**Roy Wong - Fwd: No MP09\_006 development of the Rachel Forster Hospital site**

**RE: Application No MP09\_006 development of the Rachel Forster Hospital site 134-144 Pitt Street Redfern.**

1 NORTH ELEVATION BUILDING 3 (ALBERT STREET VIEW)
SCALE 1:200

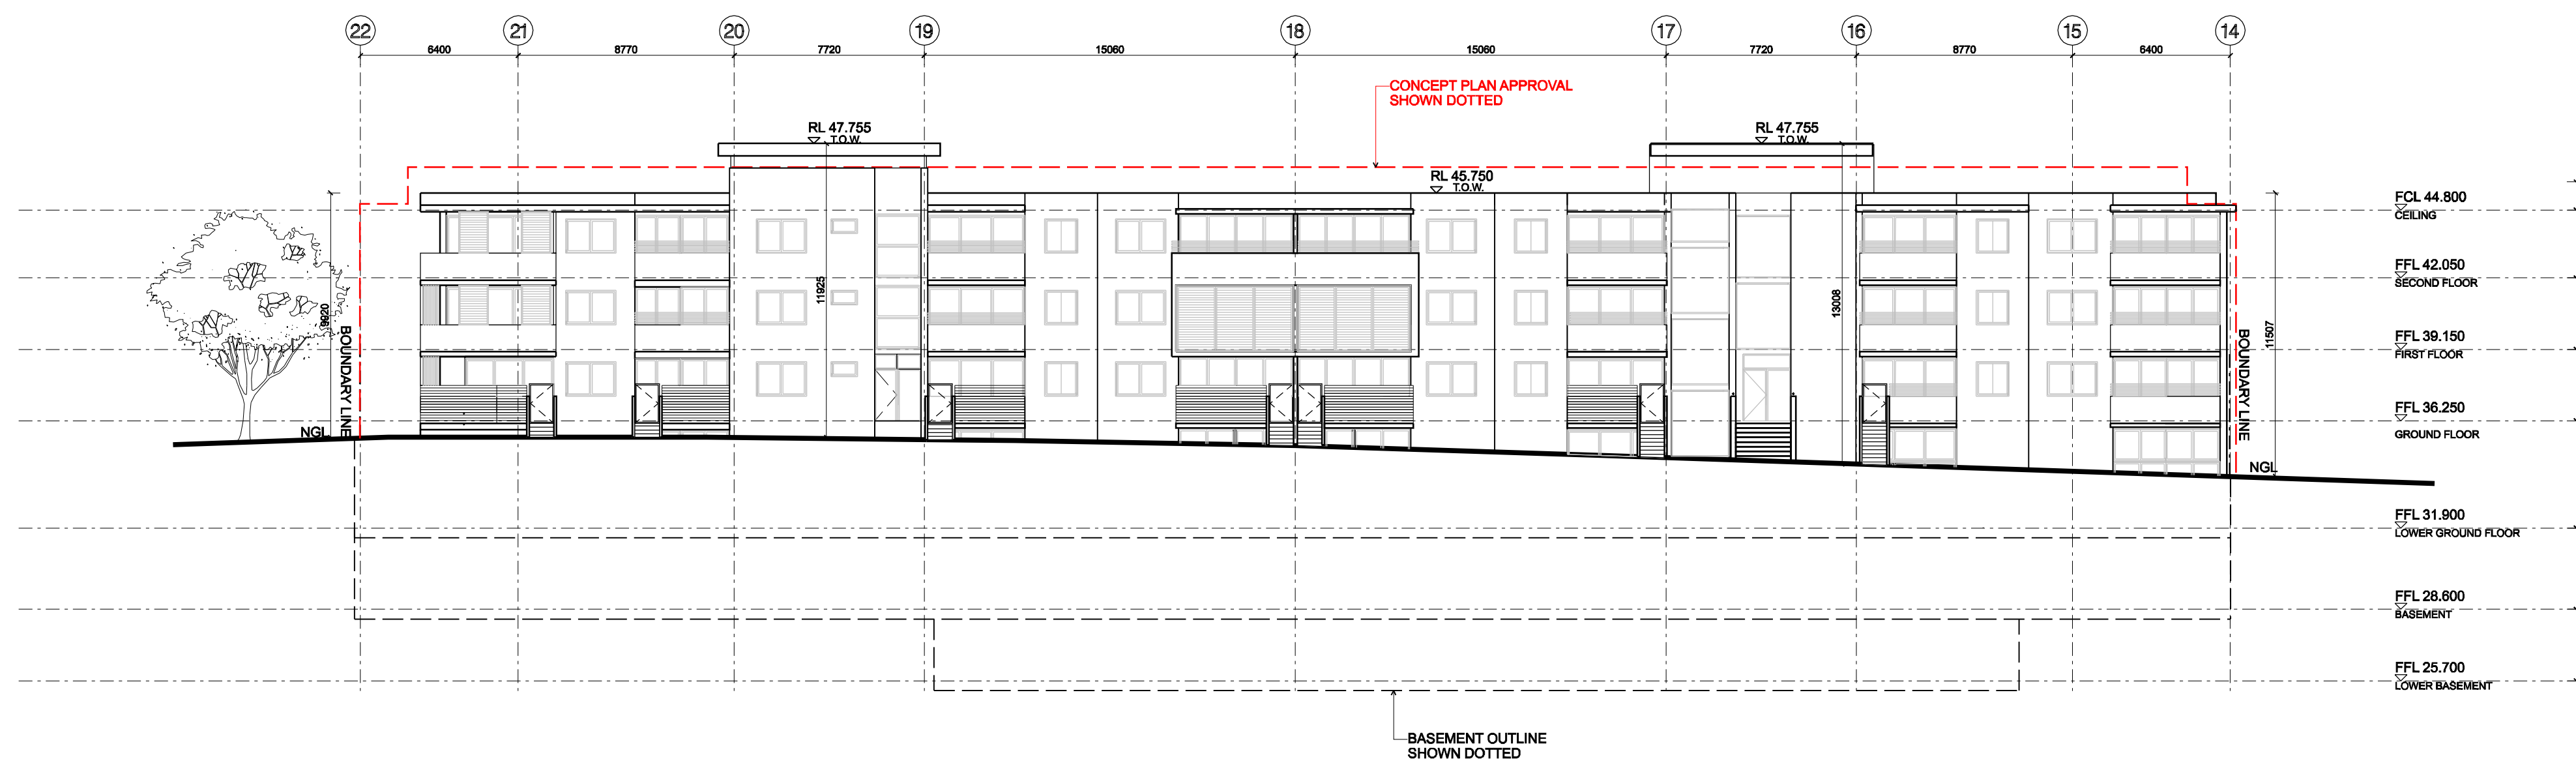
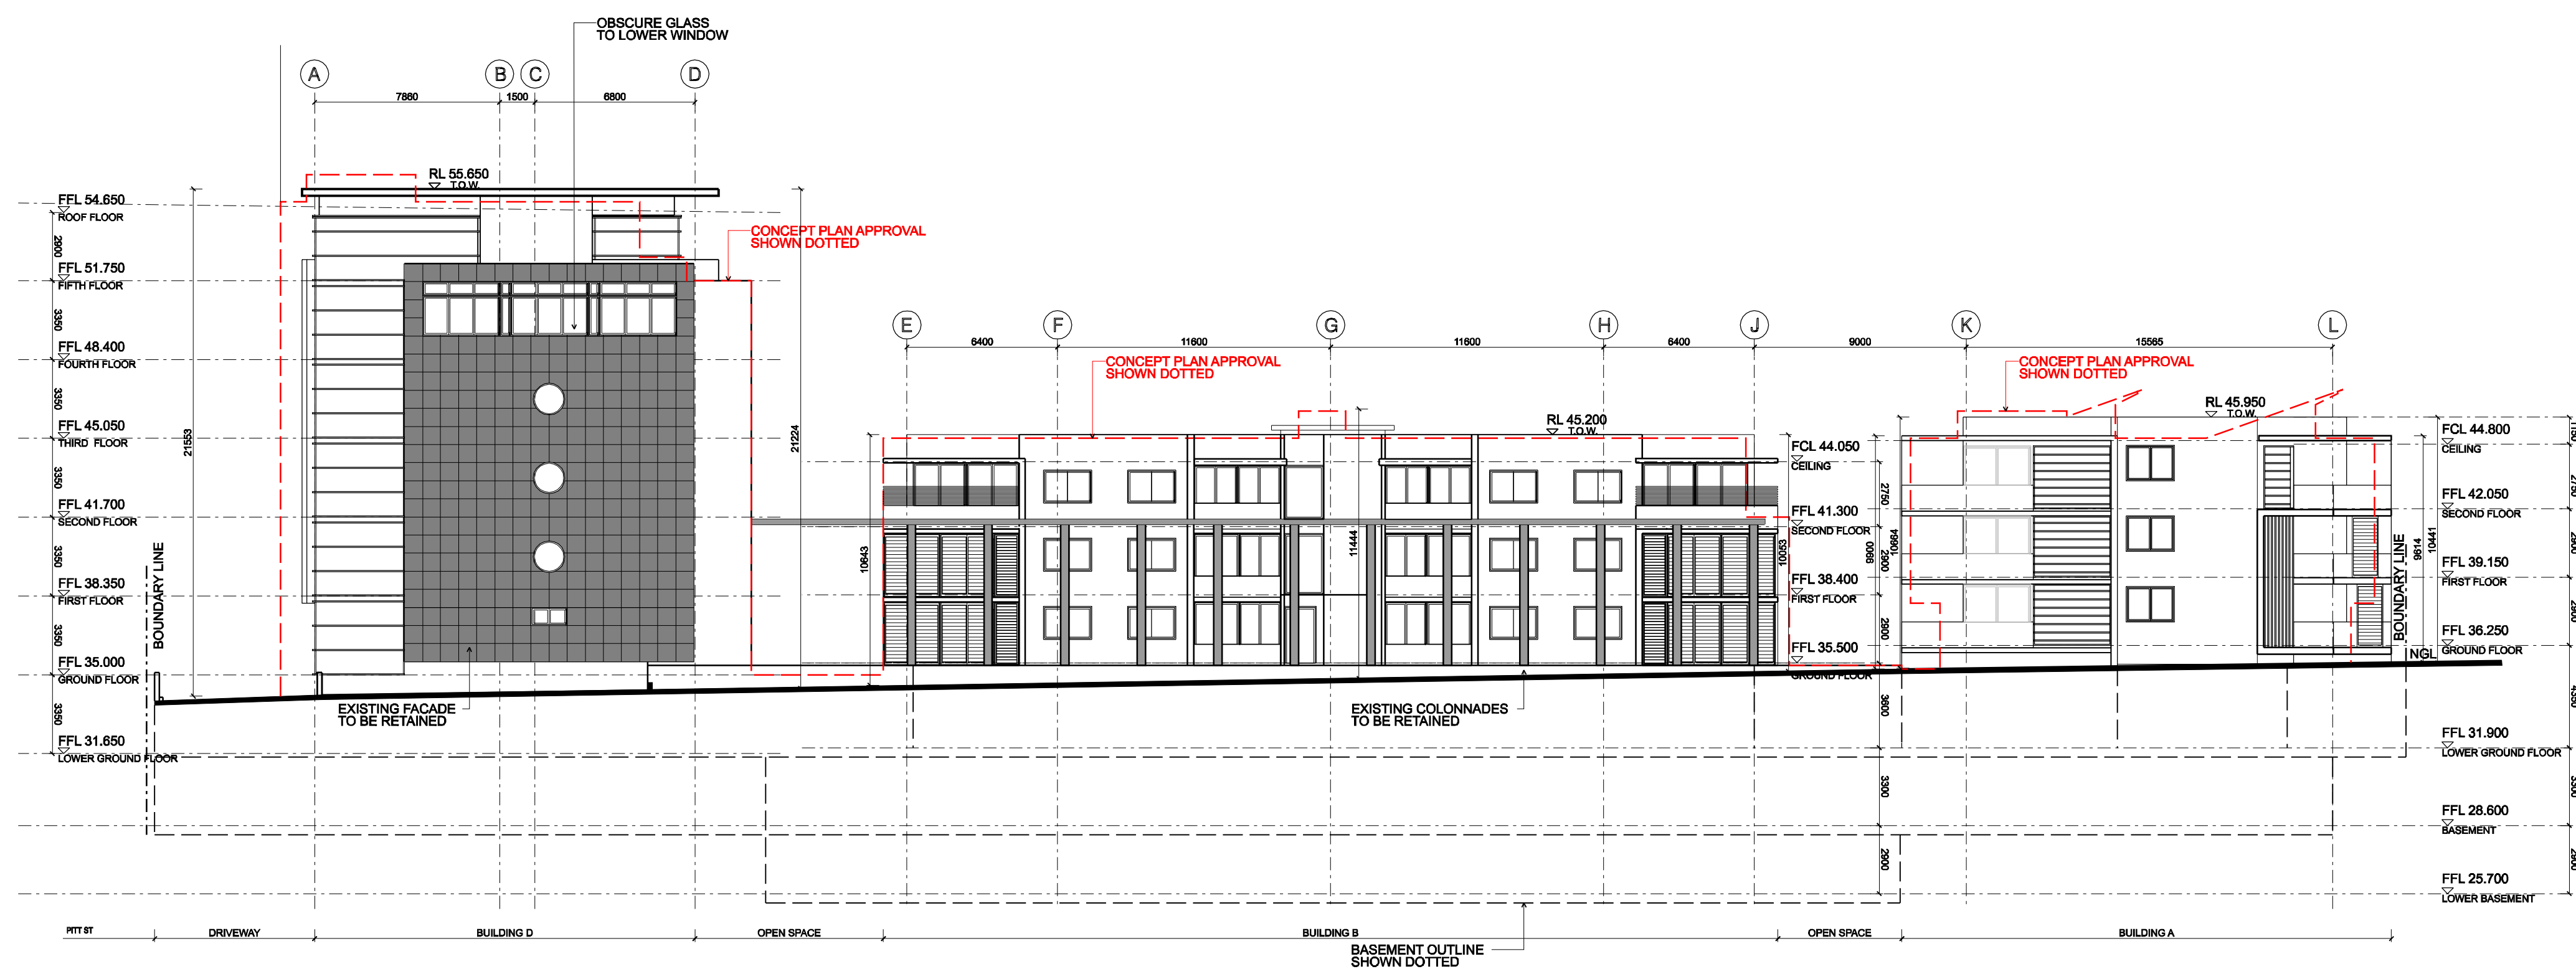
- The 46 apartments planned to be built on the Albert St boundary are too many. Further more, all will have balconies; these balconies will look directly into the bedrooms of the existing terrace houses on the north side of Albert St. This includes my own balcony.

I suggest fewer apartments be built on the Albert St boundary; and as a suggestion, perhaps townhouses as opposed to dense apartments could be built.
